# CITY OF ALBUQUERQUE

January 8, 2015

**Re: Chili's at Gibson and University  
Drainage Report and Grading and Drainage Plan  
Engineer's Stamp Date 12-30-14 (M15D012B)**

Drawing file: 12-31-14submittal / 2013086 C3 Grading.pdf

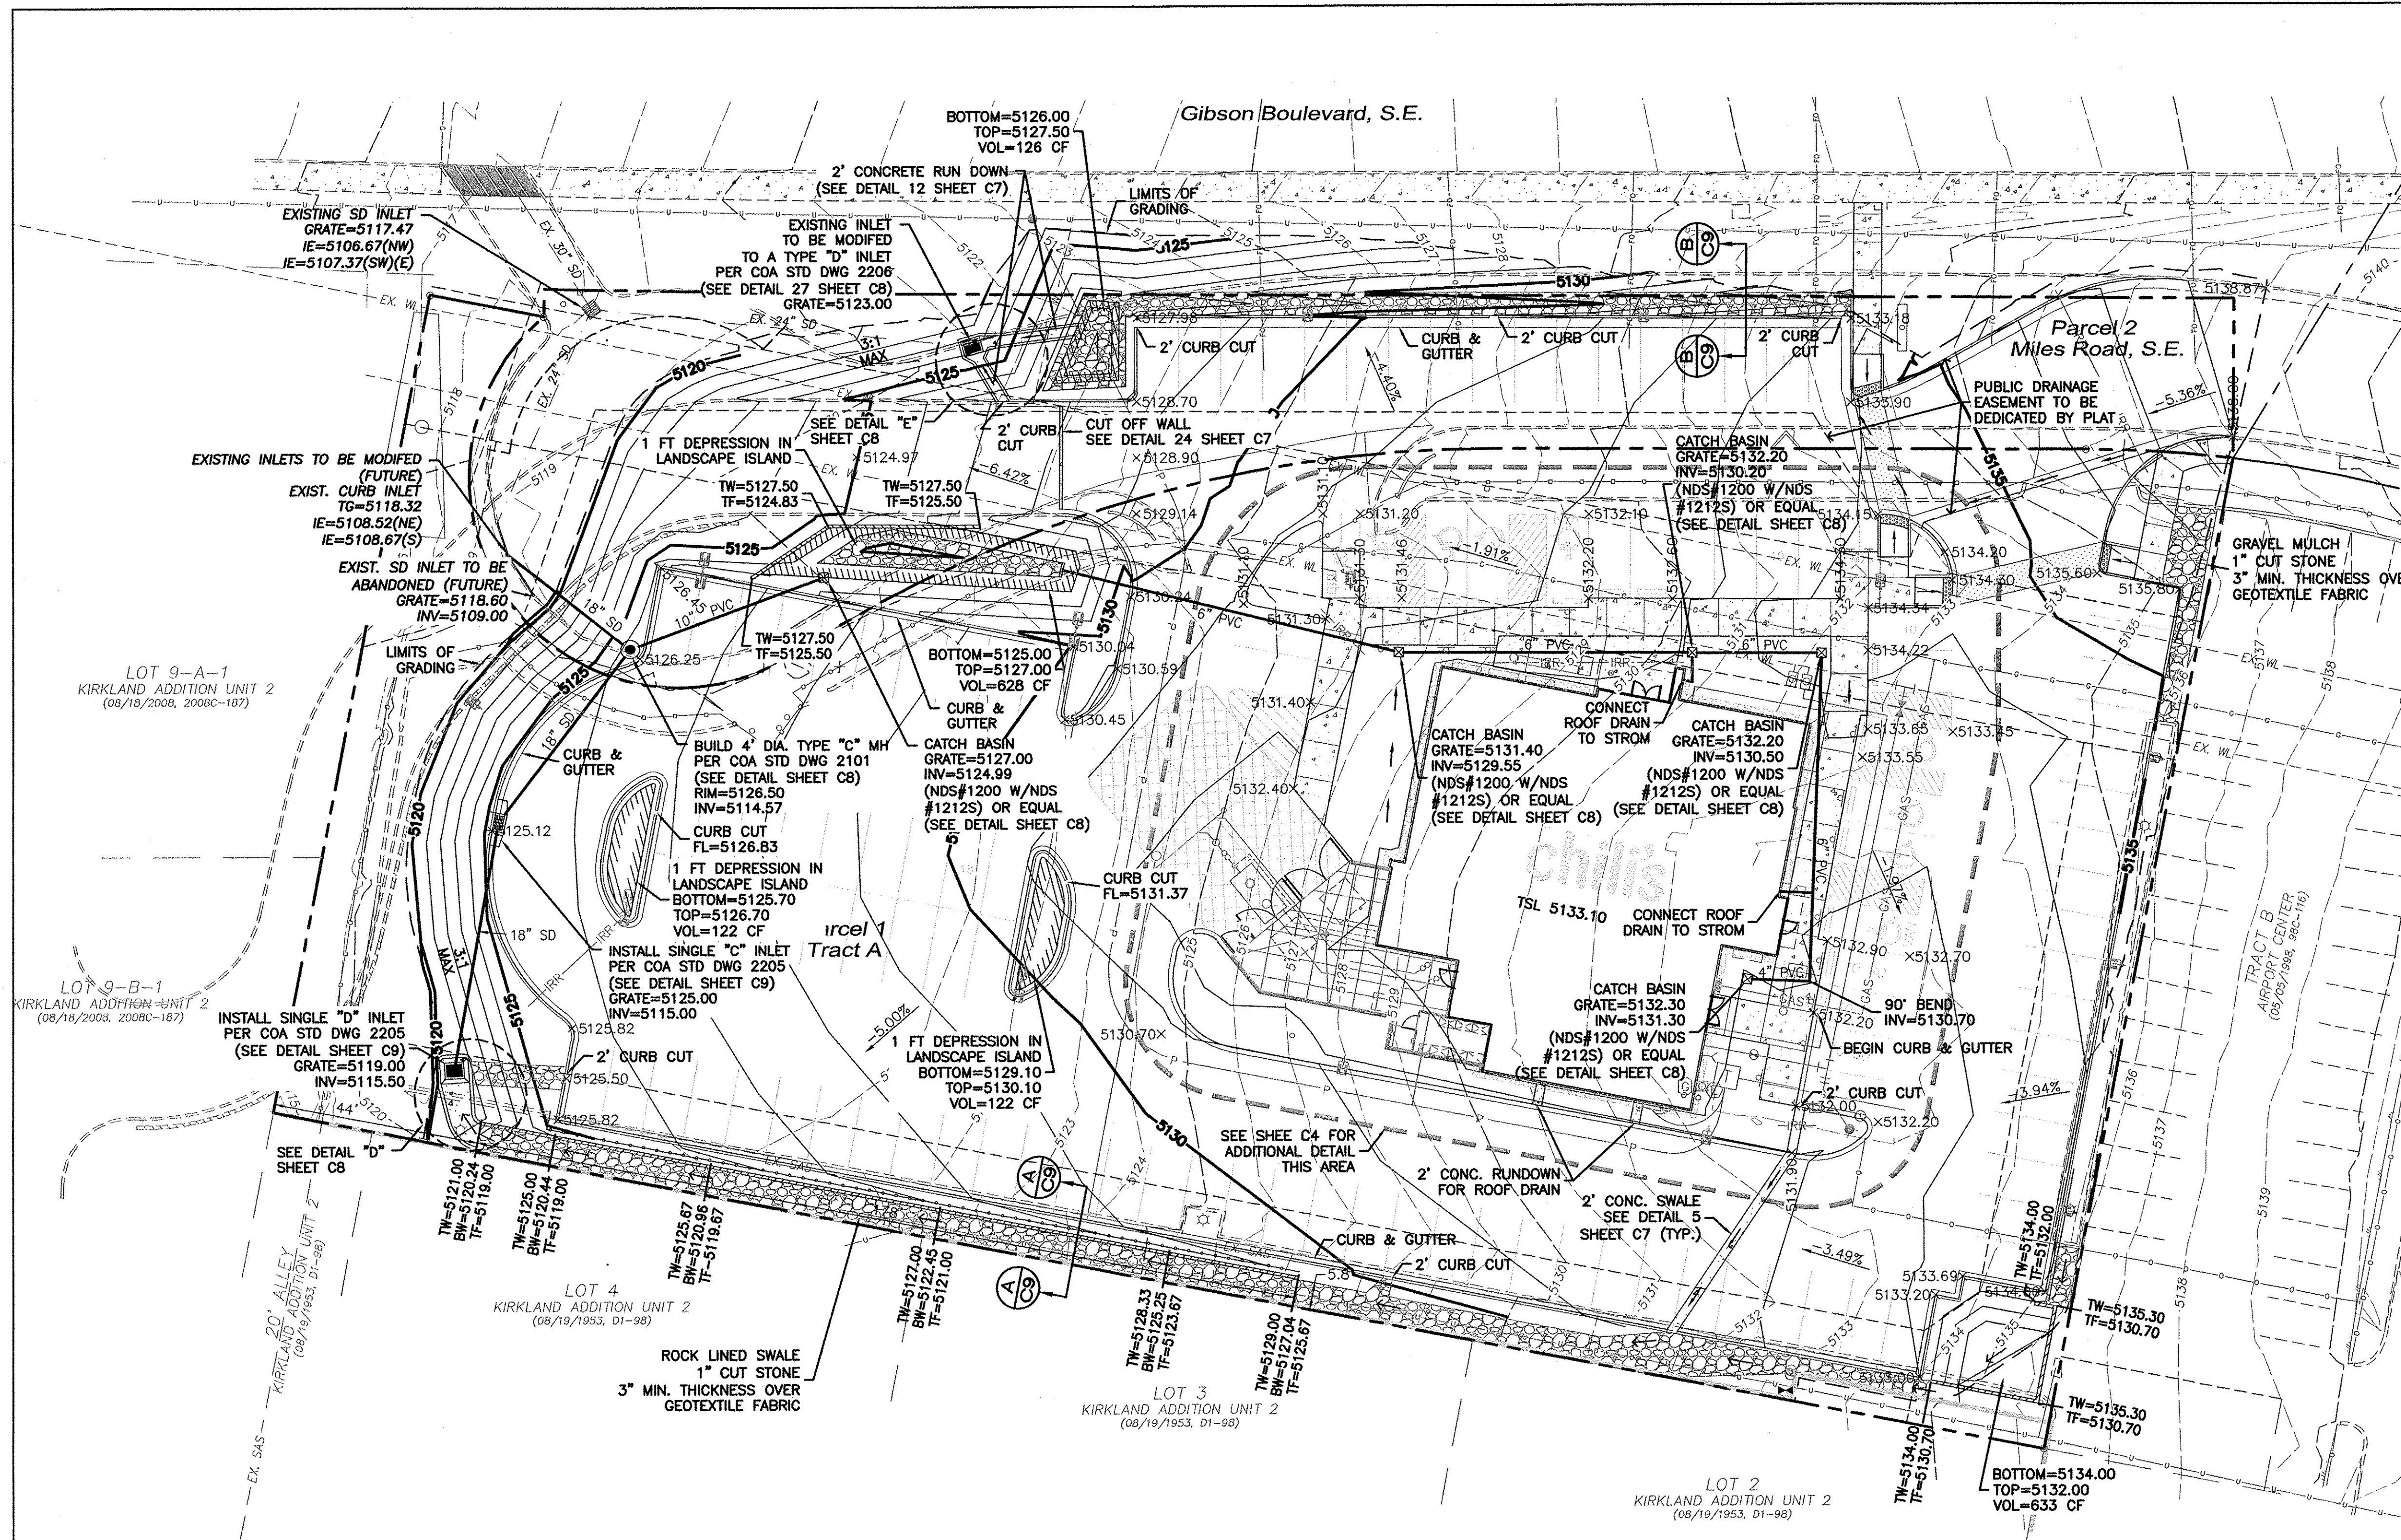
1. The vacation of Miles Road has been approved by City Council. This grading and drainage report and plan cannot be approved until the vacation is shown on the Final Plat for this site and is approved by DRB.
2. A turnaround for Miles Road will be required on the infrastructure list for Final Plat.
3. Revise the proposed drainage easement where the public drainage from Miles Road will flow in the parking lot and drainage system. Please see the enclosed exhibit for the minimum area that should be included. Include the drainage easement on the Final Plat.
4. The current grading and drainage plan cannot receive Grading Permit approval until the Final Plat is approved because the grading and drainage plan includes grading and drainage changes in Miles Road. Request Grading/Building Permit approval once the Final Plat has been approved.
